MONUMENT FIRE DISTRICT

March 13, 2024

Ref: Society of Classical Christian Education (SocCe) Site Dev plan (PPR2350)

Re: Fire Department Access

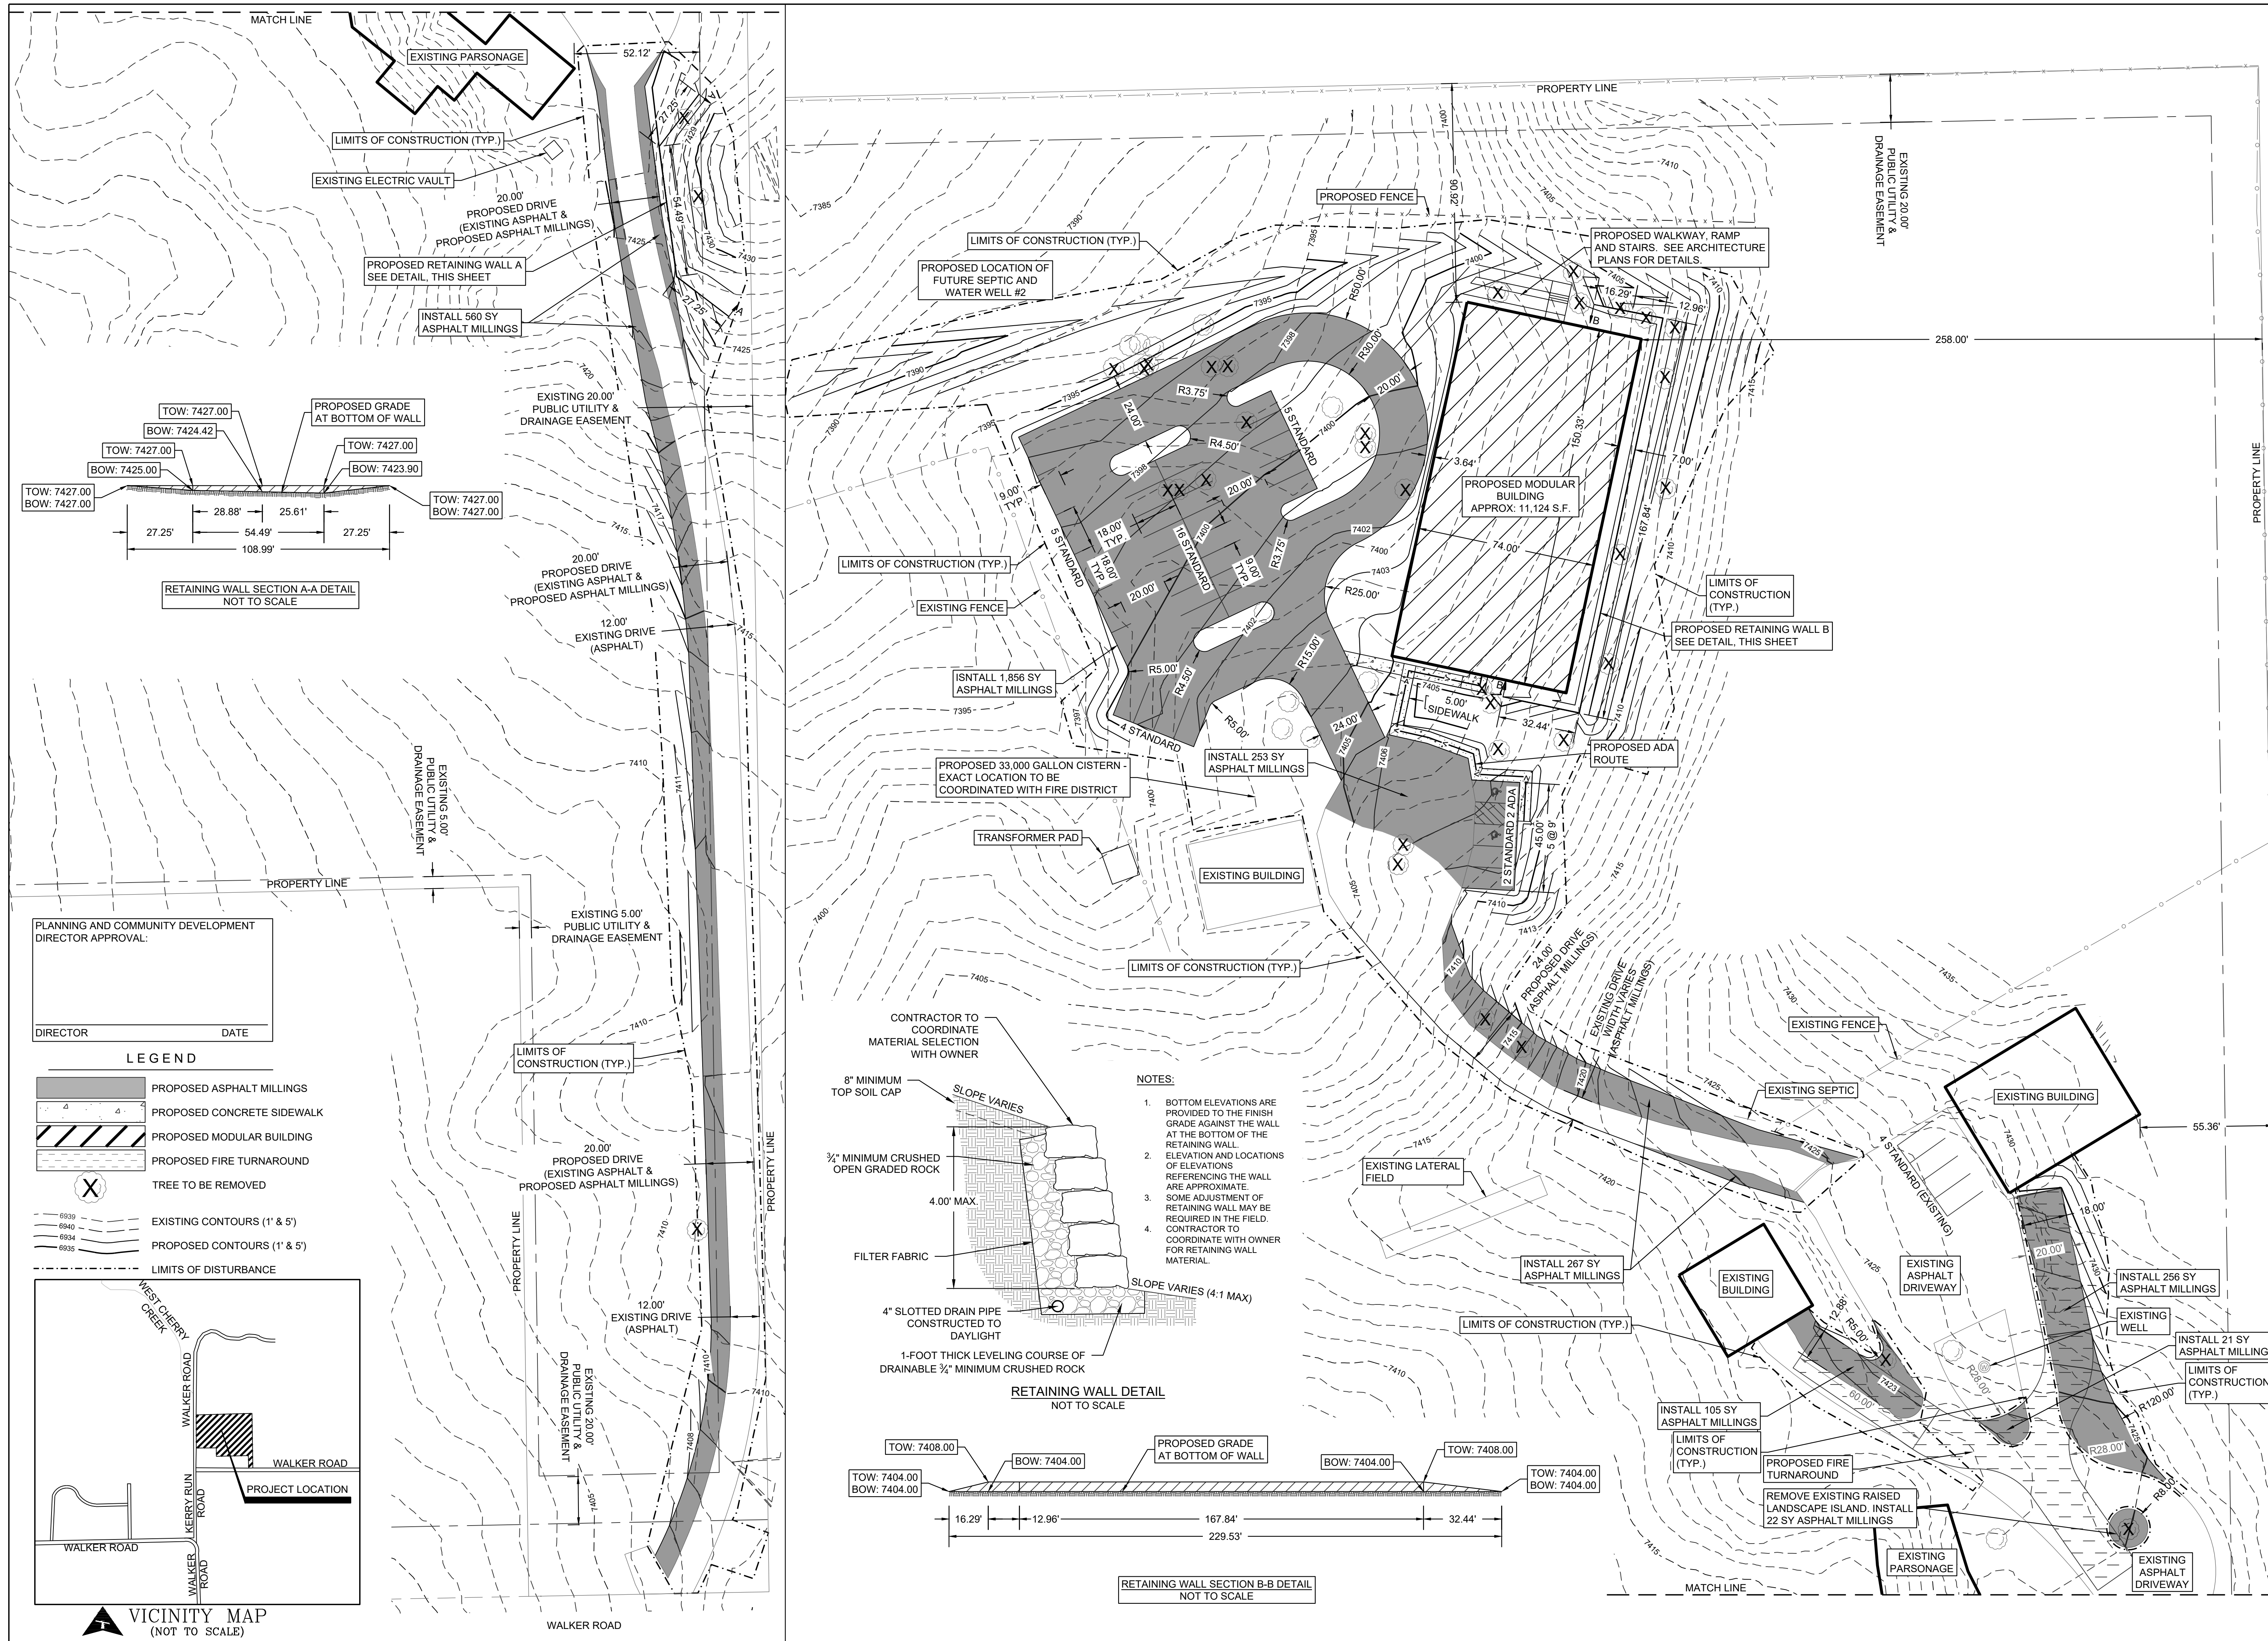
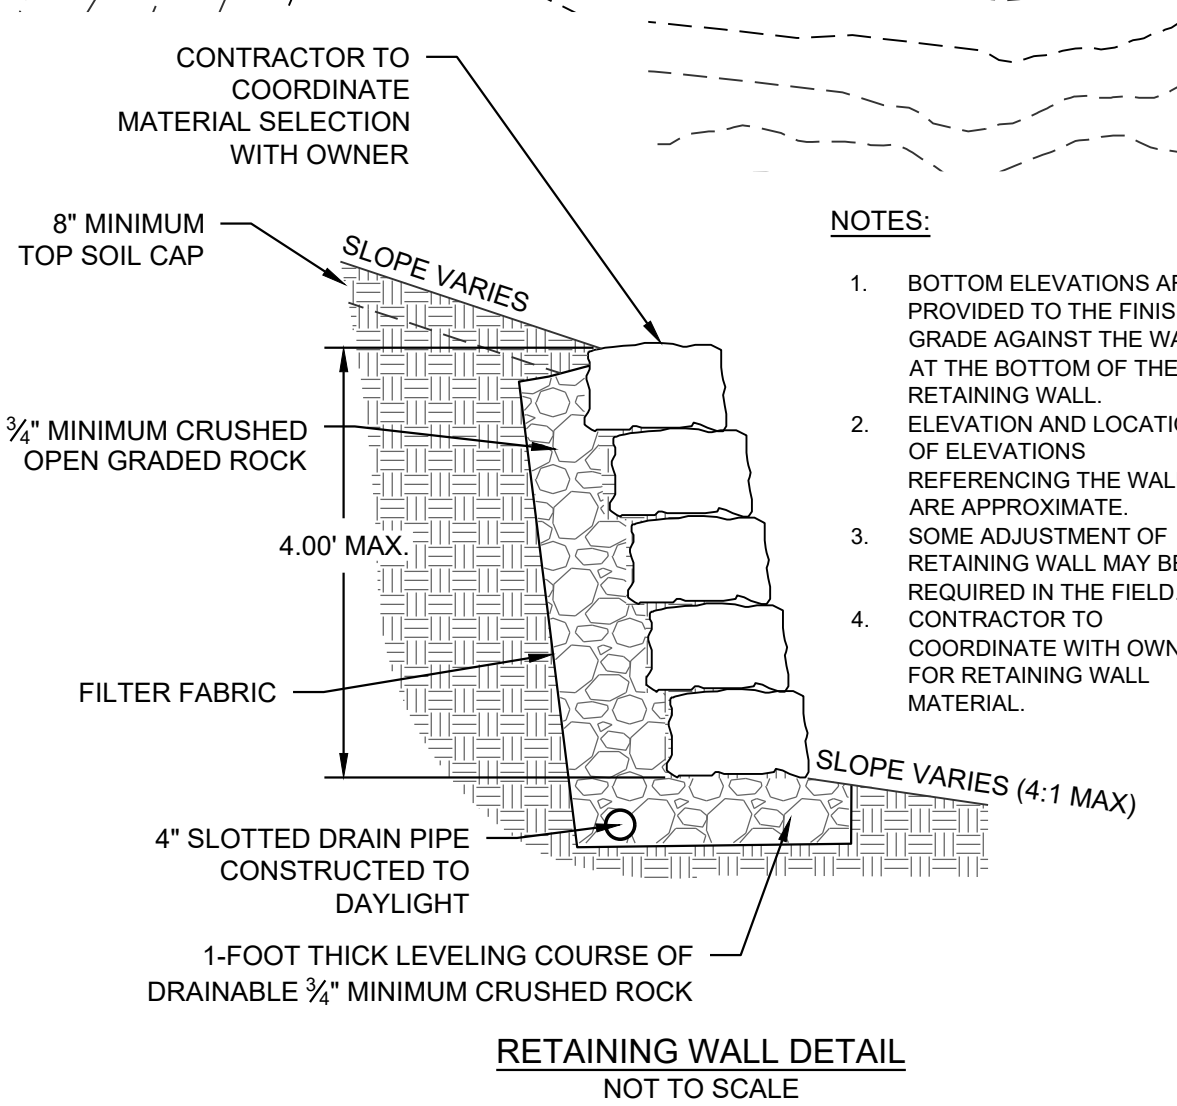
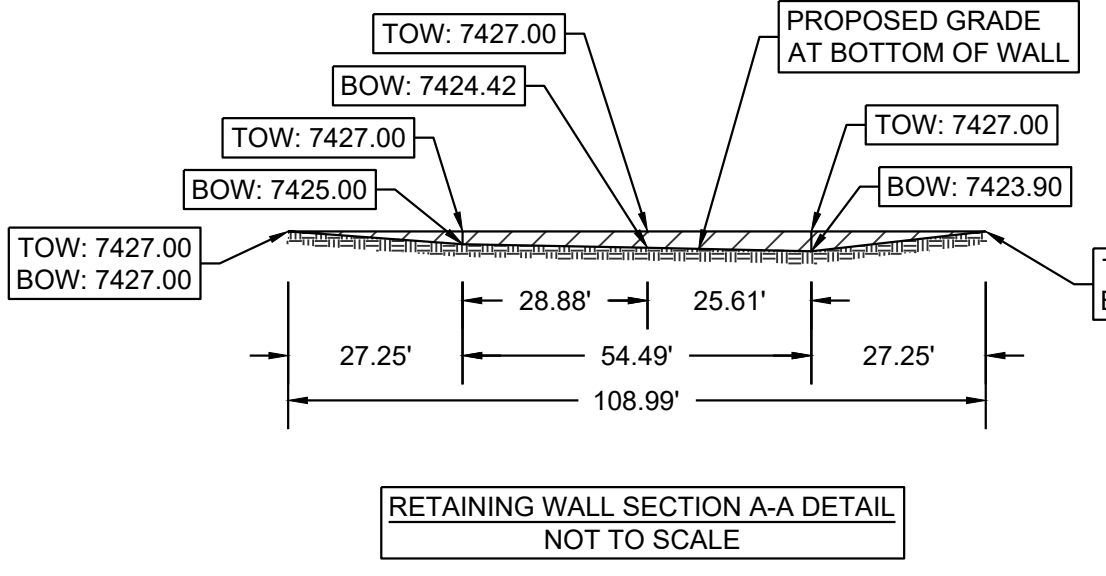
The access to 3984 Walker Road is through the current access to 3980 Walker Road and ultimately dead-ends at the proposed project site. The fire department will require the access road for 3980 Walker Road to meet the current International Fire Code 2015 Local Amendments Section D102-Required Access. The current driveway must be modified to meet the 20-ft width and an approved driving surface capable of supporting an imposed load a 75,000 lb fire apparatus with a minimum single axle weight of 27,000 lbs. Because the driveway is in excess of 750 ft, the fire department will require additional turnarounds along the access road. This property currently has features that can be modified to meet this requirement adjacent to the existing house and the existing garage and outbuilding. There is a island in the driveway near the existing house that is boarded raised with landscape timbers. The fire

department requests that this island, and all landscaping within, be removed to provide adequate space to park or turn around large fire and medical apparatus.

Continued access through this property will require additional modifications. The access road narrows as it passes the existing house toward the existing garage and outbuilding. This section must be modified to meet the 20 ft road width requirements. This section near the garage and outbuilding has a feature that can be modified to meet the Y-Hammerhead turnaround standard in the code referenced above (Section D103.1) to provide a second turnaround. It is requested that these modifications be made. The access road continues from this location into 3984 Walker Road.

As the access road leaves 3980 Walker Road and enters 3984 Walker Road, it transitions from asphalt to a dirt surface. The fire department recommends continuing hard surface (asphalt or concrete), but will consider alternatives as long as they meet the code referenced above (Section D102). The site plan parking area provided by the property owner is acceptable for access and turnaround purposes at the proposed site with the following recommendation: The parking lot islands and landscaped have no curb or a mountable curb for large fire apparatus to drive over. The parking lot spaces do not reduce the driving area widths that allow large fire and medical apparatus to turn around.
